**Comments on Other Submissions
Submitted at Deadline 3**

**for the
Royal Society for the Protection of Birds
and Suffolk Wildlife Trust**

**Submitted for Deadline 5
23 July 2021**

**Application by NNB Generation Company (SZC) Limited for an Order
Granting Development Consent for
The Sizewell C Project**

Figure 15. Pre and post storm beach profiles for a range of particle sizes using the 1D sand and gravel versions of XBeach for 2099 sea levels. The section shown is in the centre of the Sizewell C frontage. XBS = XBeach sand and XBG = XBeach gravel. The legend shows the sediment diameter used.

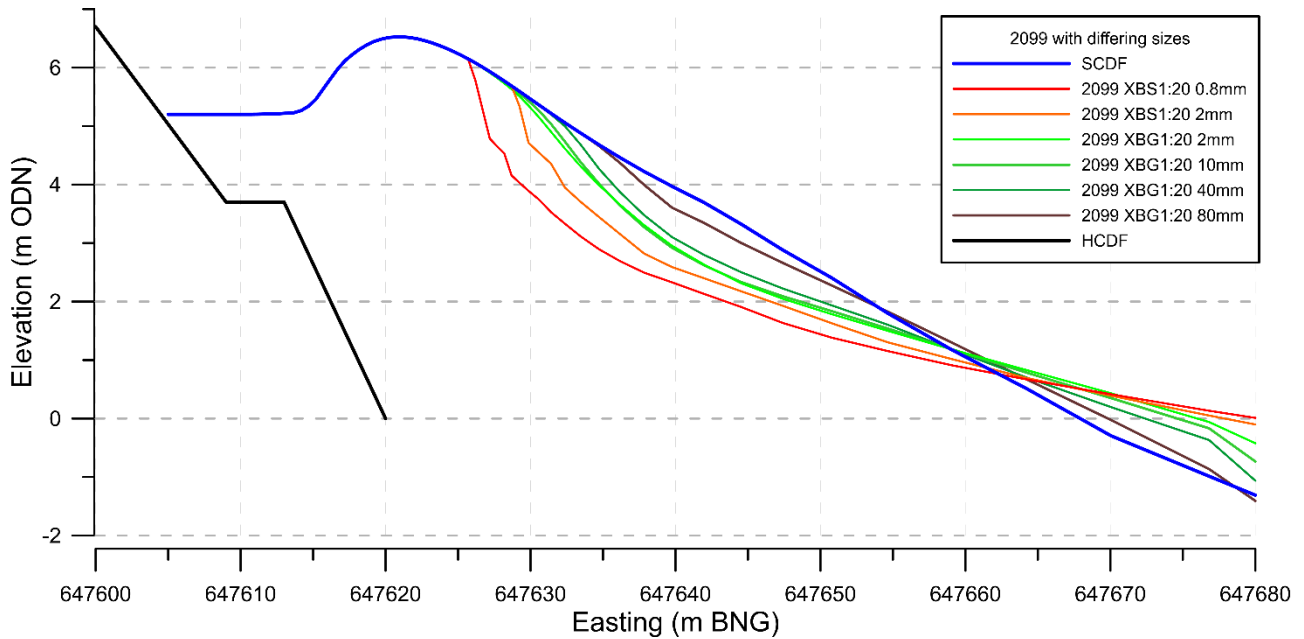
5.1. The storm erosion modelling report¹⁴ focusses on the engineering function of the SCDF. It's recommendations with regard to particle size (section 4.6.3 pg 66-67) do not appear to take account of the supra-tidal shingle and the SAC/Coastal Wildlife Site features raised in our Deadline 3 response¹⁵. We recognise that work is ongoing, but would **welcome confirmation that the environmental assessment will be progressed to recognise the concerns we have raised.**

Figure 1: main development site Bat Tree Roost Inspection Results 2021

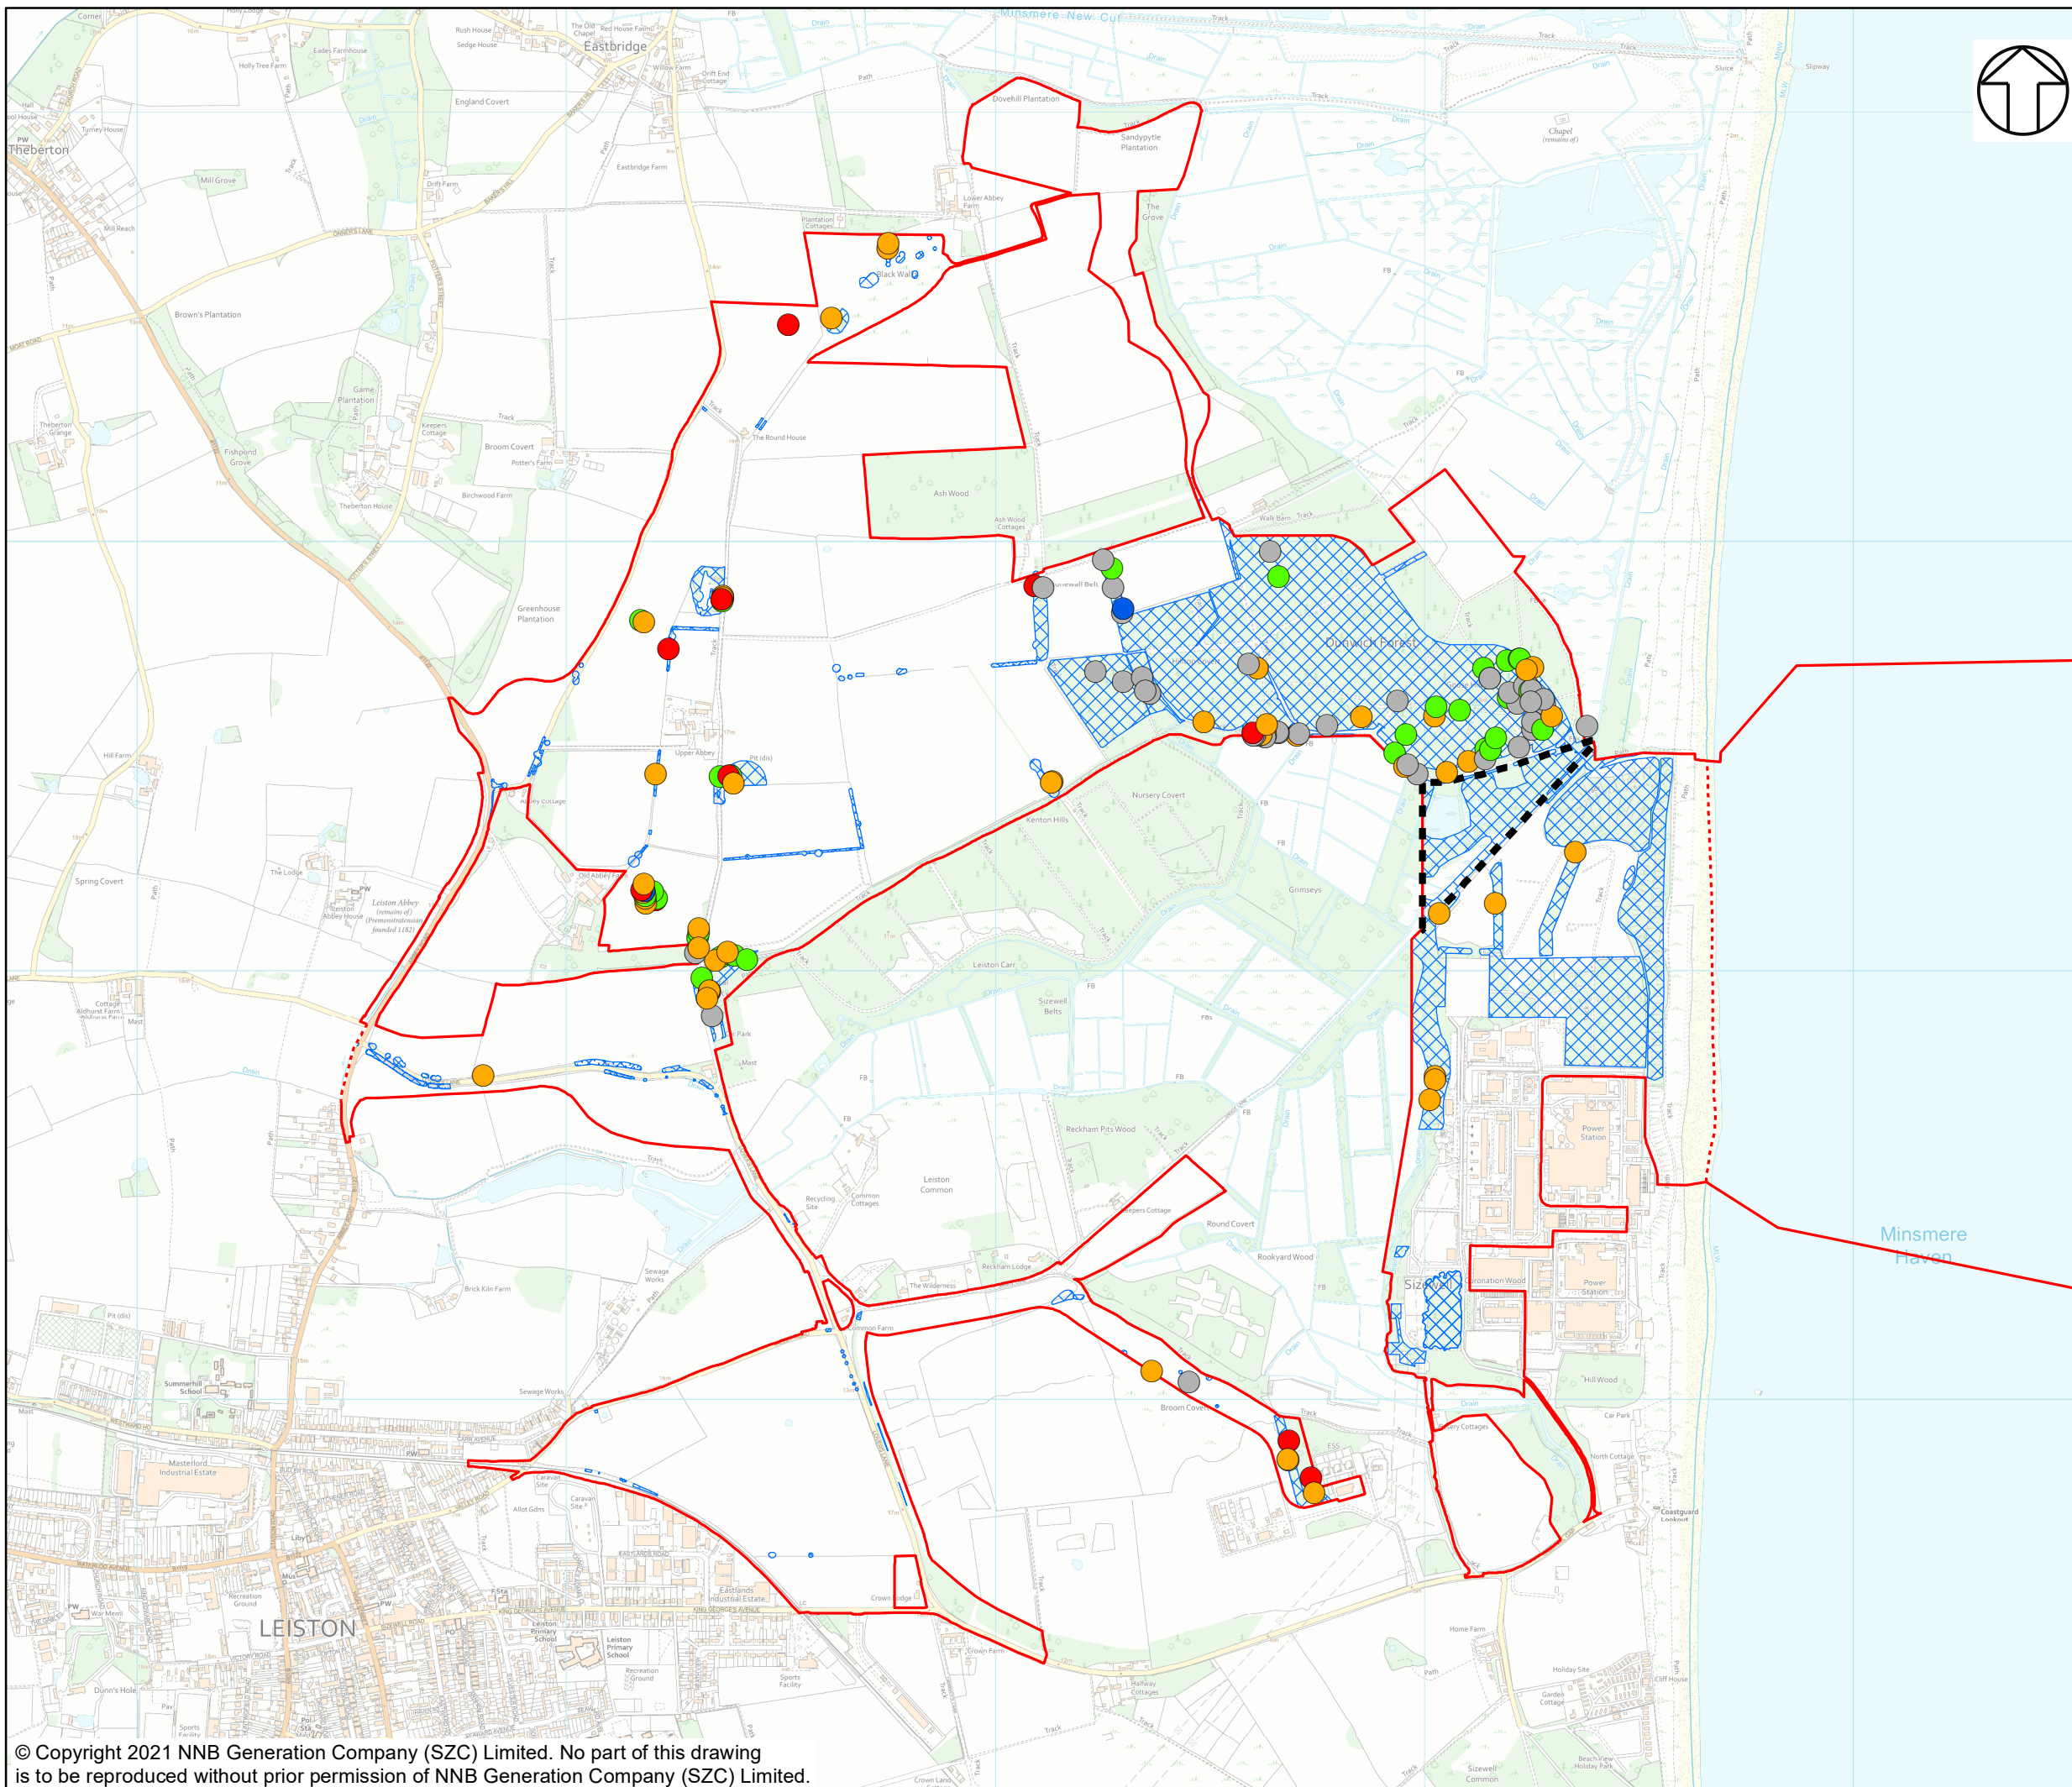
- 1.1. We have provided comments on bat roost surveys in trees – main development site submitted at Deadline 3¹ that now includes Appendix A Figure 1 Bat Tree Roost Inspection Results 2021.
- 1.2. We provided comments on the same report submitted at Deadline 2 without Figure 1² in our Comments on Other Submissions (submitted at Deadline 2)³, due to it not being submitted until Deadline 3. Our further comments below relate to the figure.
- 1.3. As the Applicant acknowledges (paragraph 6.1.5)

where proposed vegetation removal is likely to remove potential roost clusters, in locations such as north of Kenton Hills car park and the boundary features to the north of Goose Hill Plantation, the effect on the local bat population is likely to be greater than locations where a single potential roost resource is being lost.

DRAWING TITLE:
BAT ROOST INSPECTION RESULTS 2021
SHEET 5 OF 14

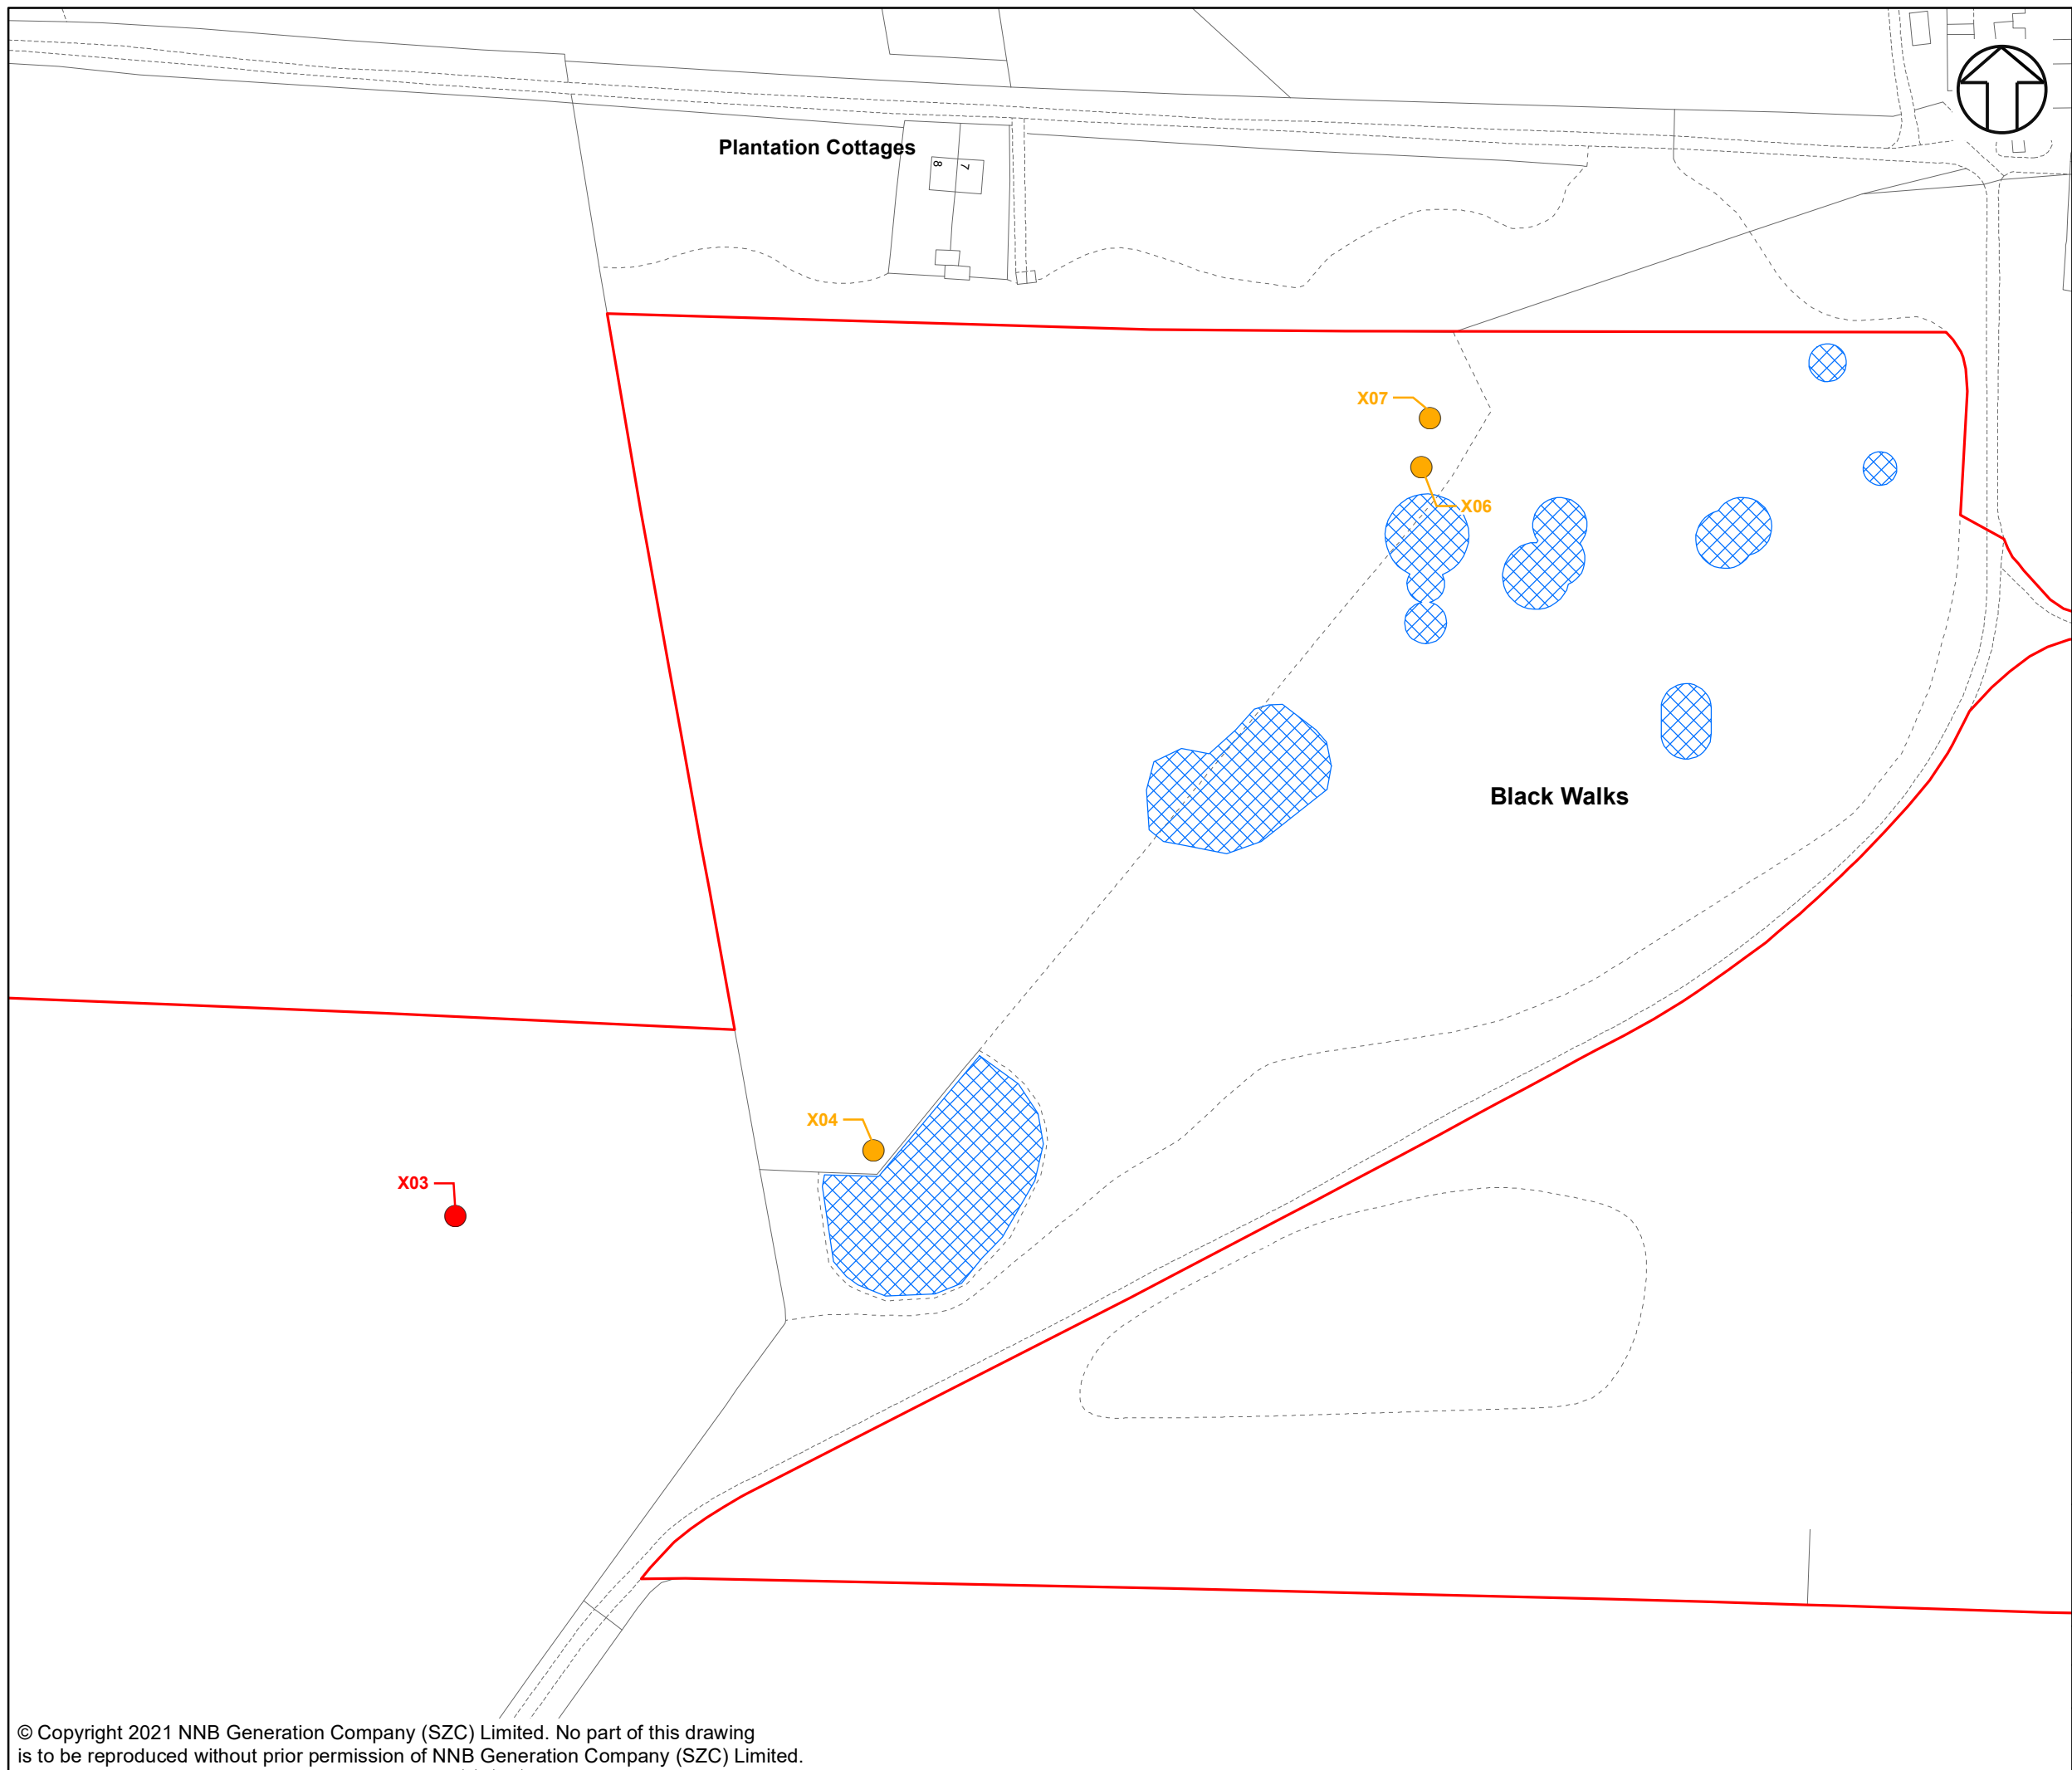
- 1.4. Figure 1 shows clusters of high and moderate potential trees will be lost north of Upper Abbey Farm (sheet 3), in Fiscal Policy (sheet 5), in the south of Goose Hill (sheet 10). This is a concern and further mitigation for loss of potential roost sites is required.
- 1.5. It is still not clear if the assessment included in depth review of the roost resources in Goose Hill and the SSSI triangle as previously requested, or simply a re-visit of the trees already flagged.
- 1.6. We request the Applicant confirms this and provides an assessment of the roost potential of trees in Goose Hill and the SSSI triangle. Our concerns over the lack of survey data in Goose Hill and the SSSI triangle are detailed in our Written Representations⁴ submitted at Deadline 2.
